MEADOWBROOK PARK
 PLANNED UNIT DEVELOPMENT (PUD) PLAN

County File Number: PUDSP208

MEADOWBROOK PARK PLANNED UNIT DEVELOPMENT (PUD) AND PRELIMINARY PLAN

F SCREEN WALL DETAIL
N.T.S

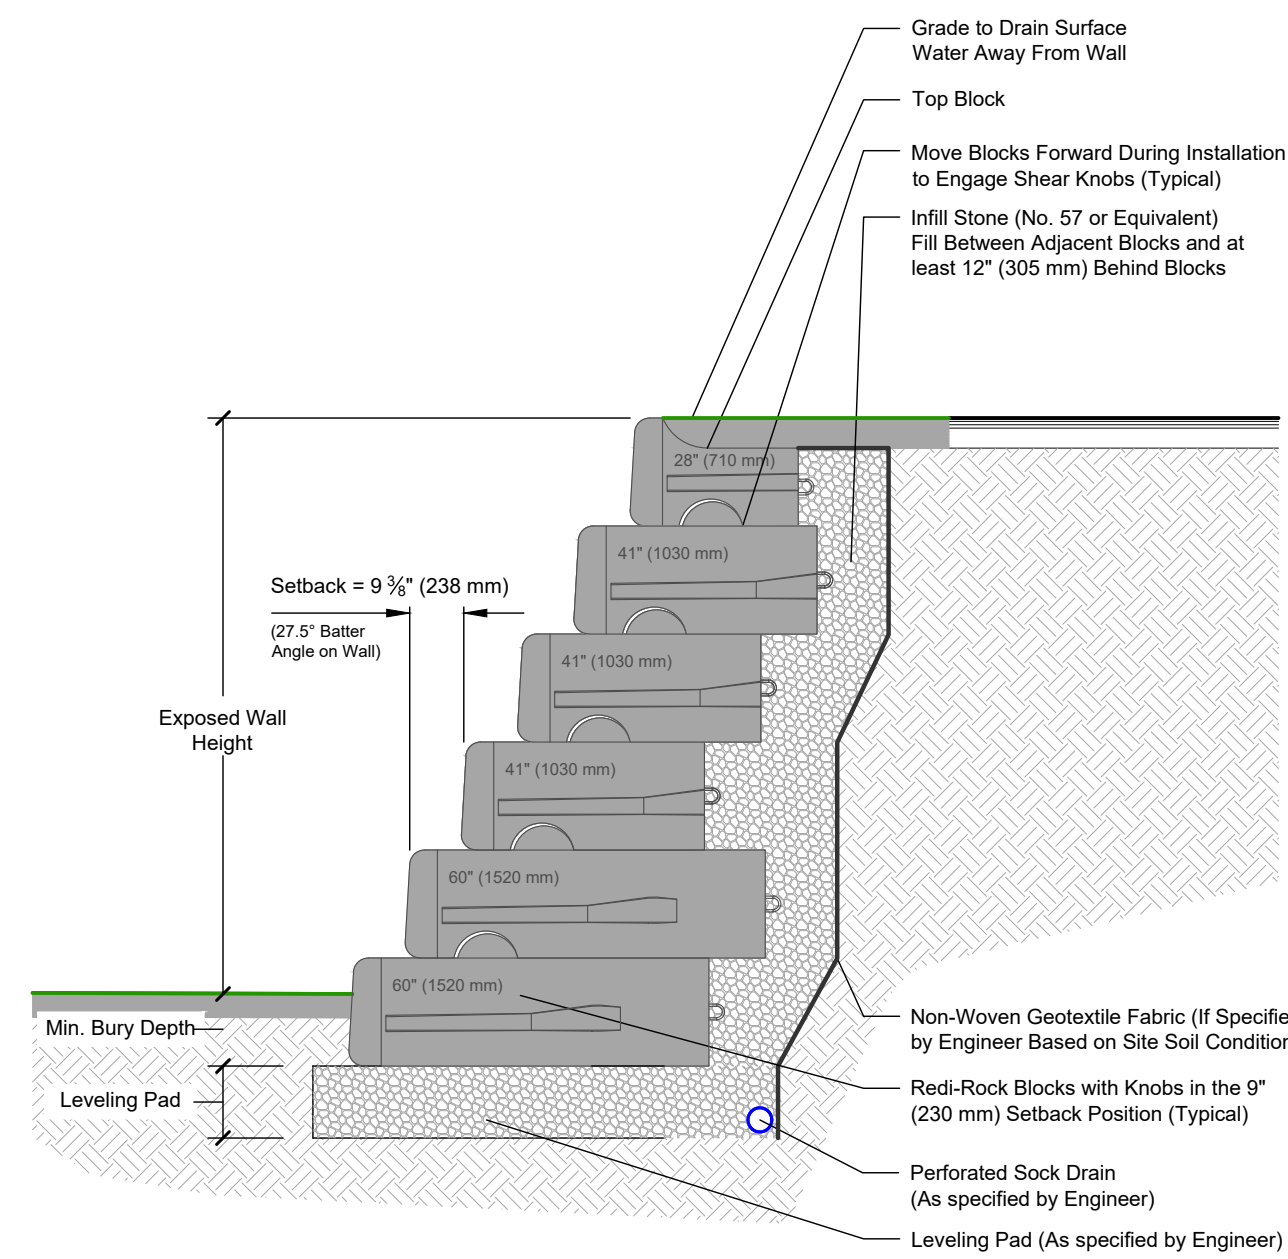
is this noise wall as noted on sheet 1 along Meadowbrook Parkway?

04 OF 10

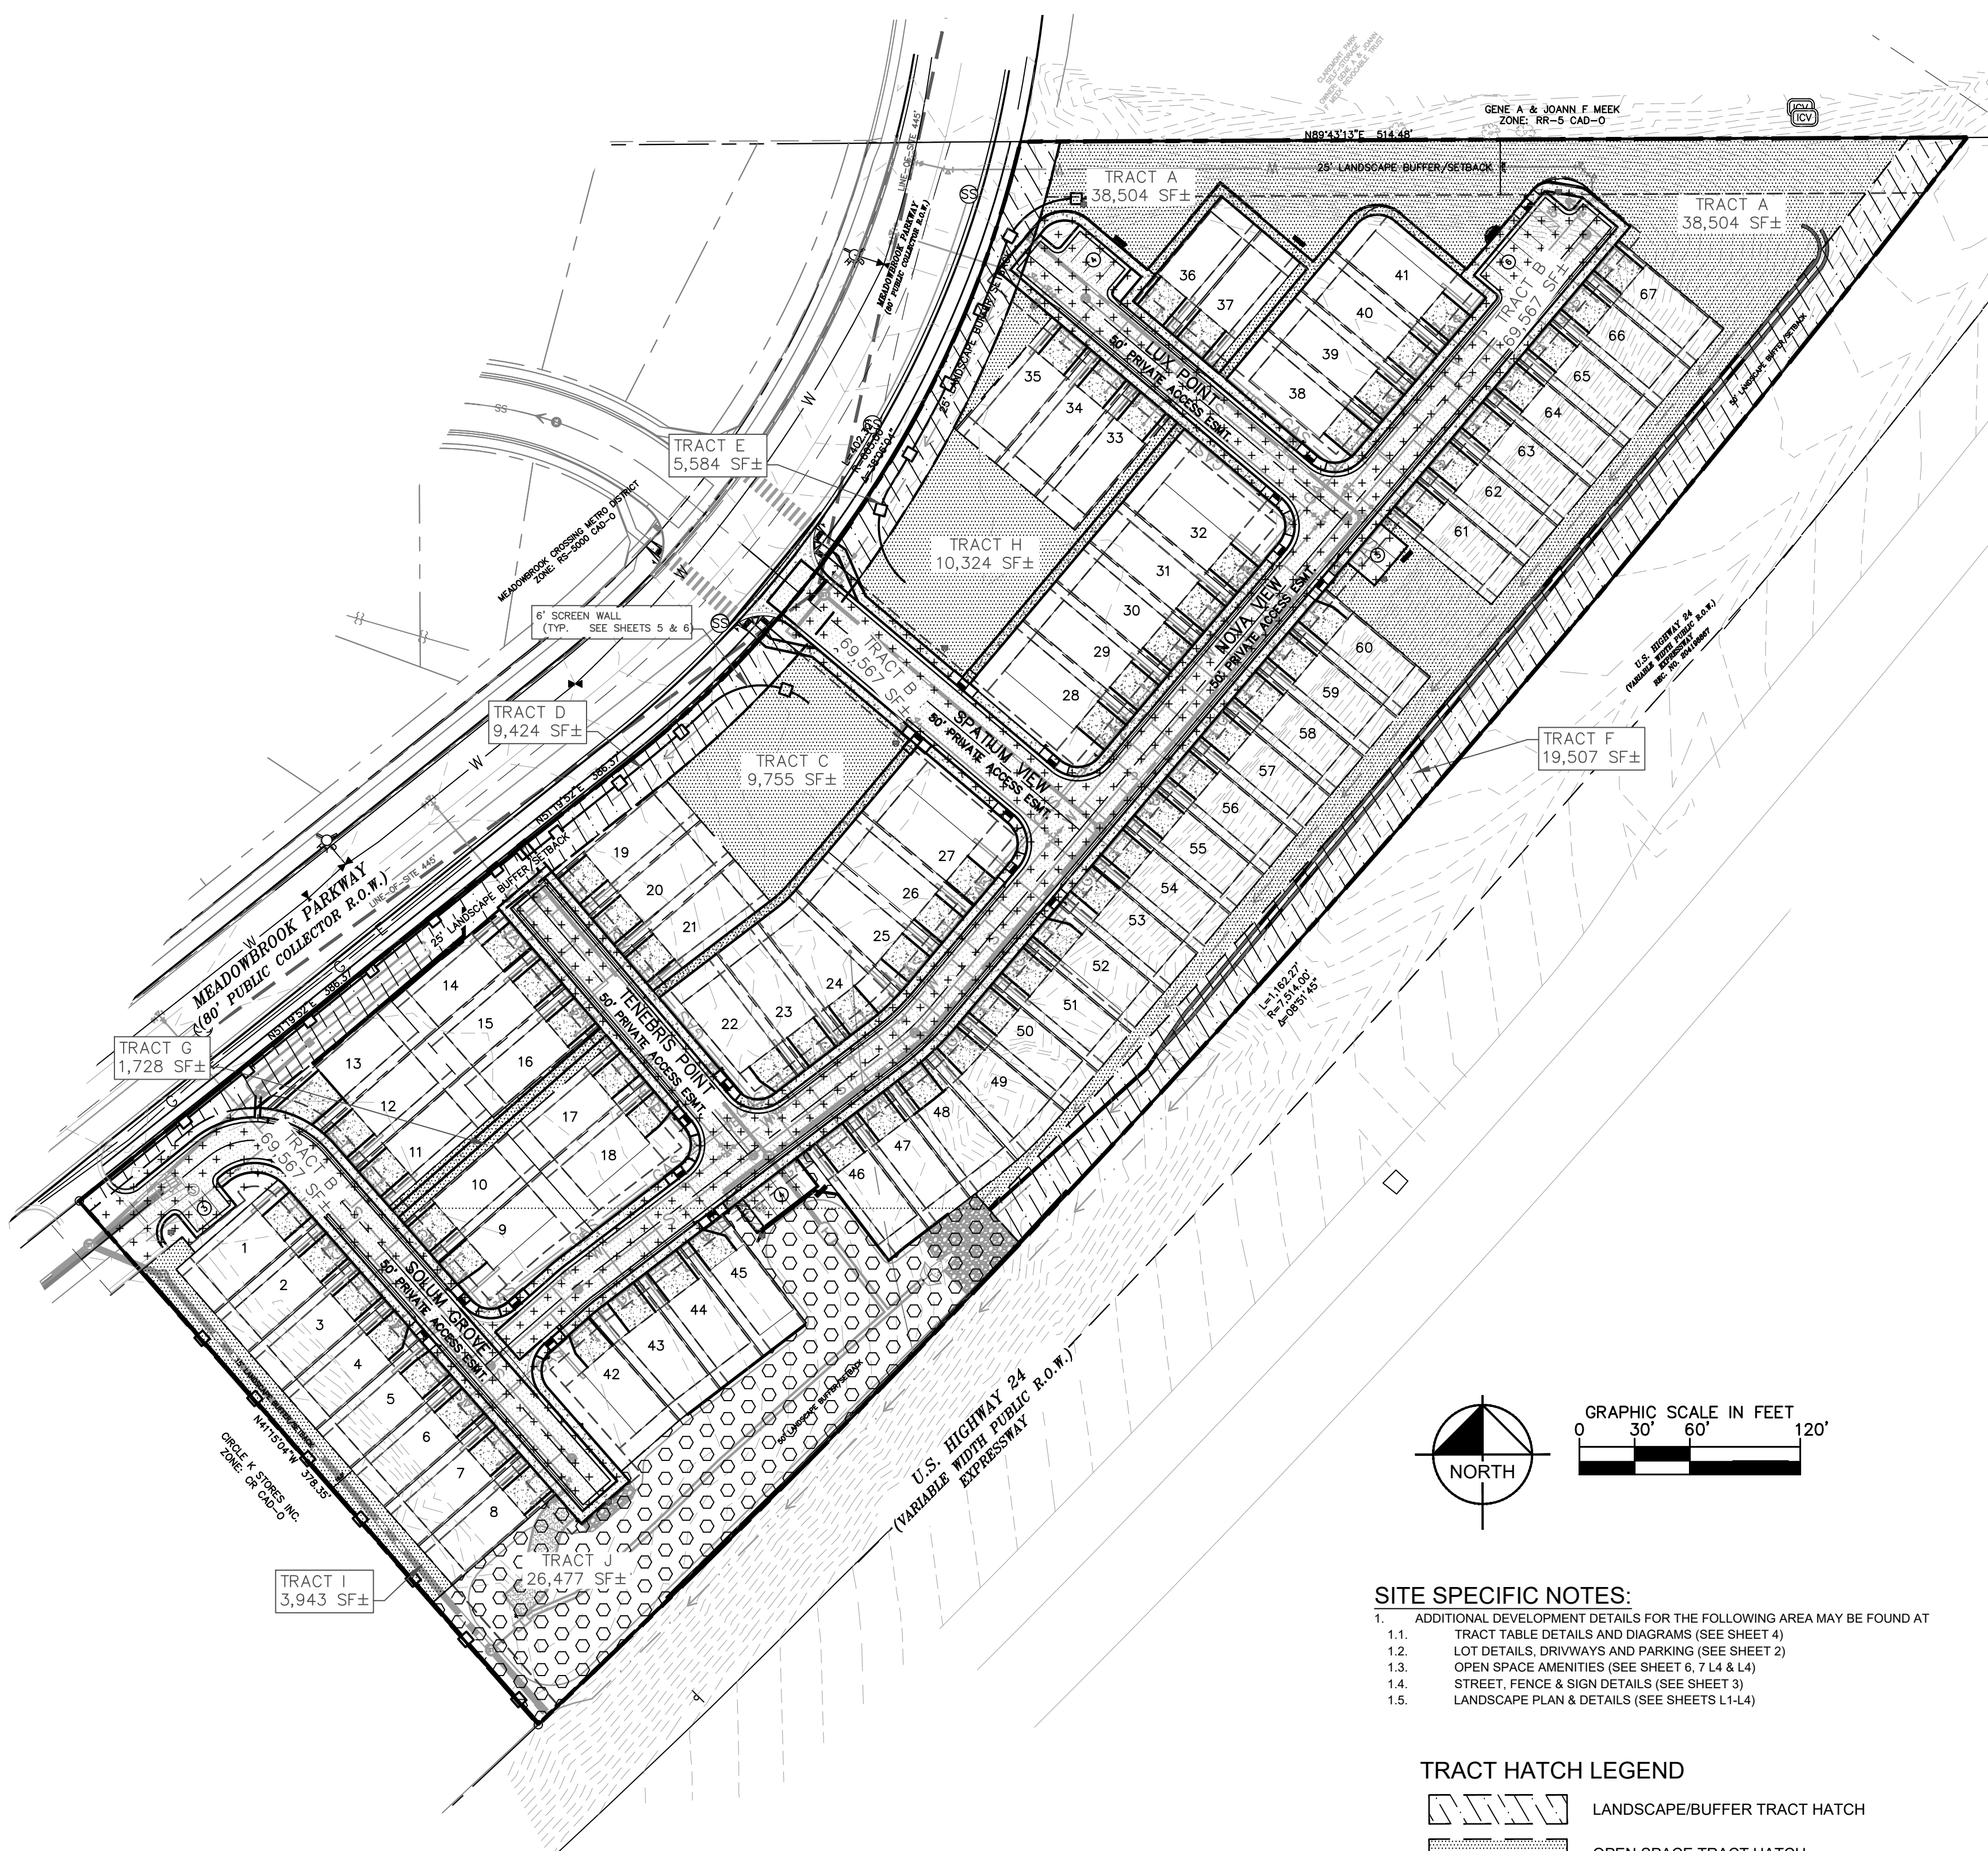
Show and label sight distance lines

add the 2 ADA spaces on all parking scheme pages

MEADOWBROOK PARK
PLANNED UNIT DEVELOPMENT (PUD) PLAN
LANDSCAPE PLAN

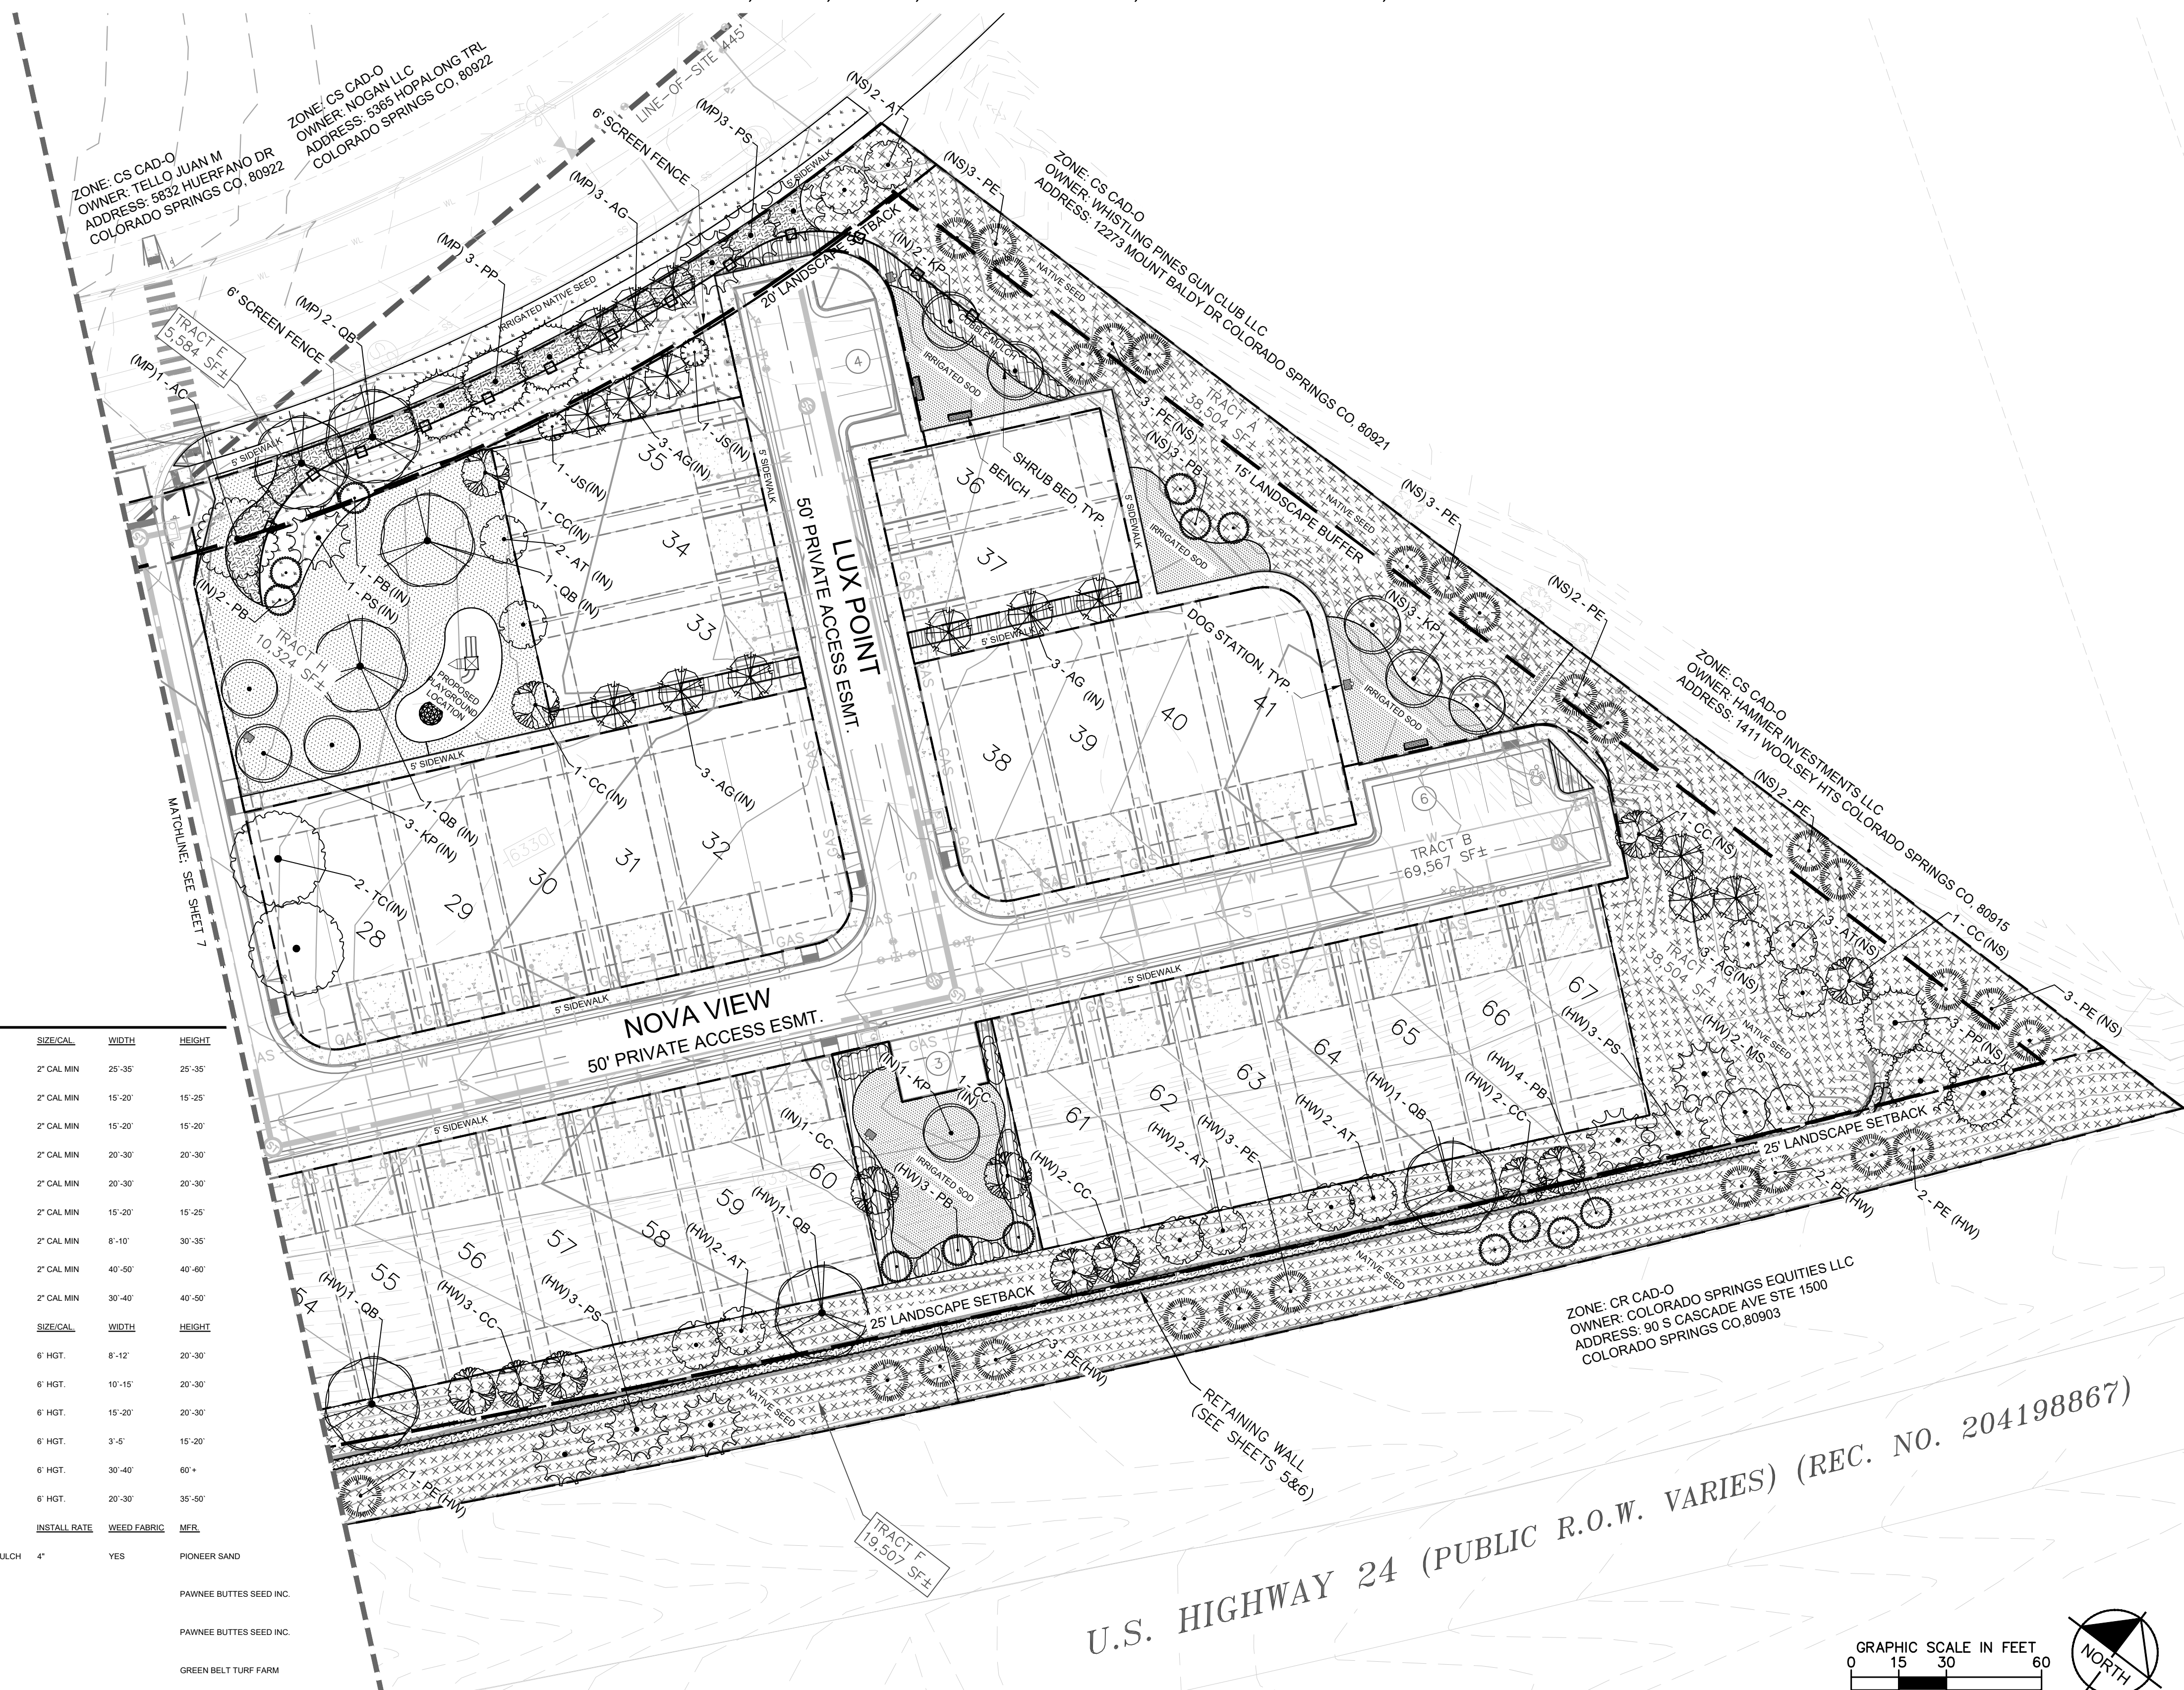
Show the sight distance lines on the LS sheets as well
